Subject: RE: Planning Consultation on: WA/33/22/DOC

Application No: WA/33/22/DOC
Registered: 11th April 2022
Site Address: 1 The Chase Fontwell Walberton BN18 0GR
Description of Works: Approval of details reserved by condition imposed under WA/124/21/HH relating to condition 3-surface water drainage.

At this stage we **would not recommend discharge of conditions** until the following comments are addressed.

Client	Fuller Associates
Drawing Title	SW Drainage Layout

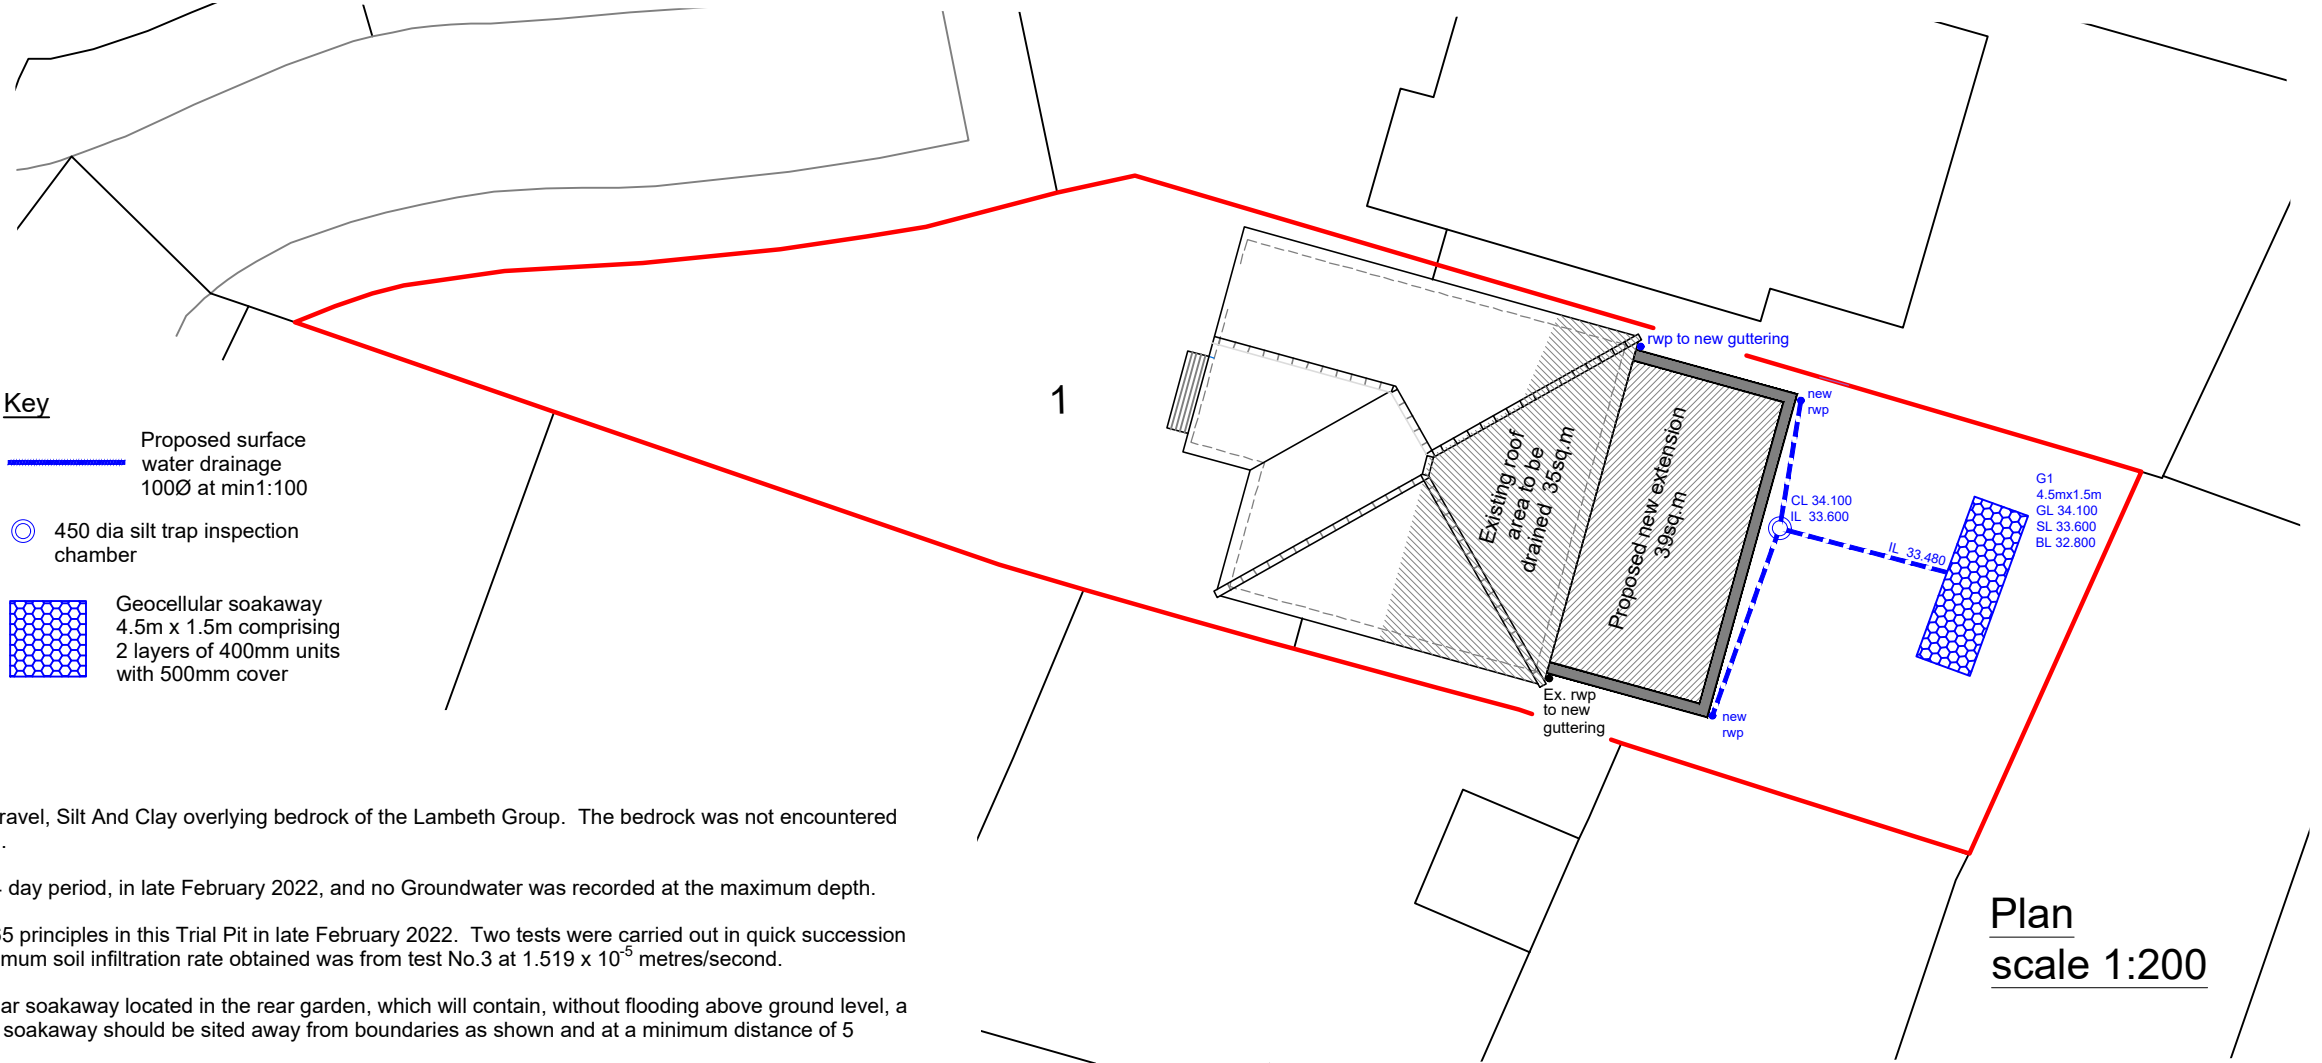
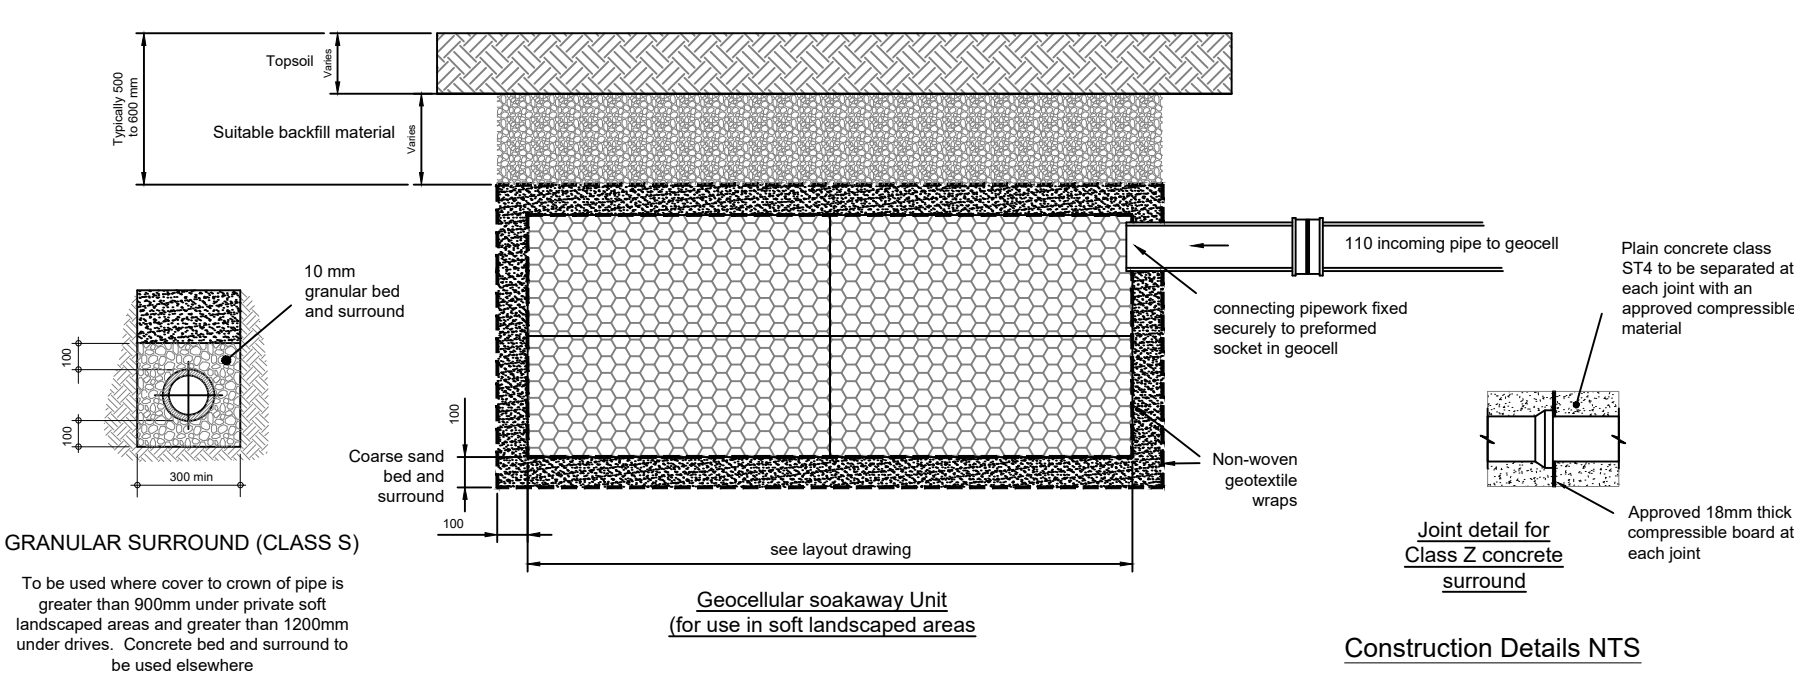
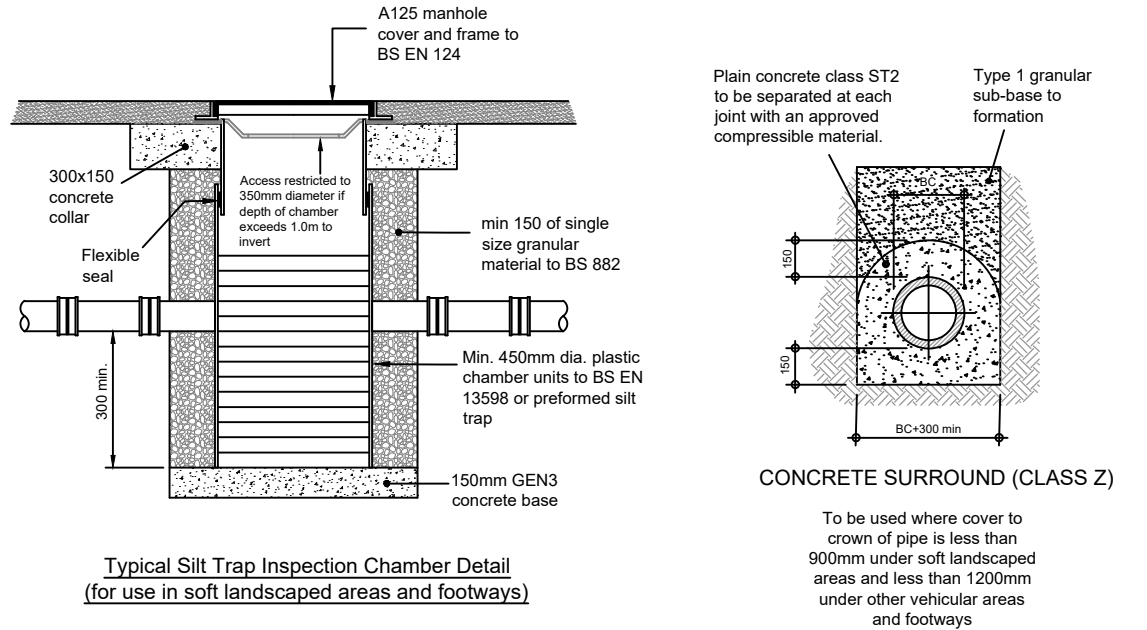
- The applicant should confirm the existing drainage for the site and determine whether the new soakaway will replace the existing soakaway. All inflows to the existing soakaway will need to be accounted for in any replacement design, alongside the proposed extension.

- If the new soakaway will sit adjacent to the existing soakaway a 10m easement will be required between the 2 soakaways (due to possible interference).

2. Additional information is required on the design drawings.
 - A manufacturer specification for the crates is required.
 - The drainage layout plan should include a scale bar.

- The location of the access point to facilitate the maintenance and inspection of the soakaway should be shown on the drawings.
3. Two pipes on the proposed drainage layout are located very close to the wall of the extension and could potentially interfere with the foundations in this area. If this is proposed as shown, details should be provided to demonstrate how the pipe run will not impact the foundations. Regardless of whether this drainage run is shown indicatively on the drainage layout plan, a more precise drawing should be submitted to show the actual proposed location.

4. A plan showing the location of both the infiltration test trial pit and groundwater monitoring point should be provided.
5. The site is located in a groundwater source protection zone (Zone 2), as a result it is necessary to confirm that the proposed soakaway will not present an undue hazard to underlying groundwater.

6. The applicant should confirm that the soakaway is located outside of the root protection zone (RPZ) for the trees located within gardens of the adjacent properties.

7. The applicant should provide a statement or sketch plan to confirm that surface water flows will not be directed into the property in the event that the soakaway was to fail, or if its capacity is exceeded. This is particularly important if the rear door of the property provides an access which is flush to the ground level, i.e. with no raised threshold.
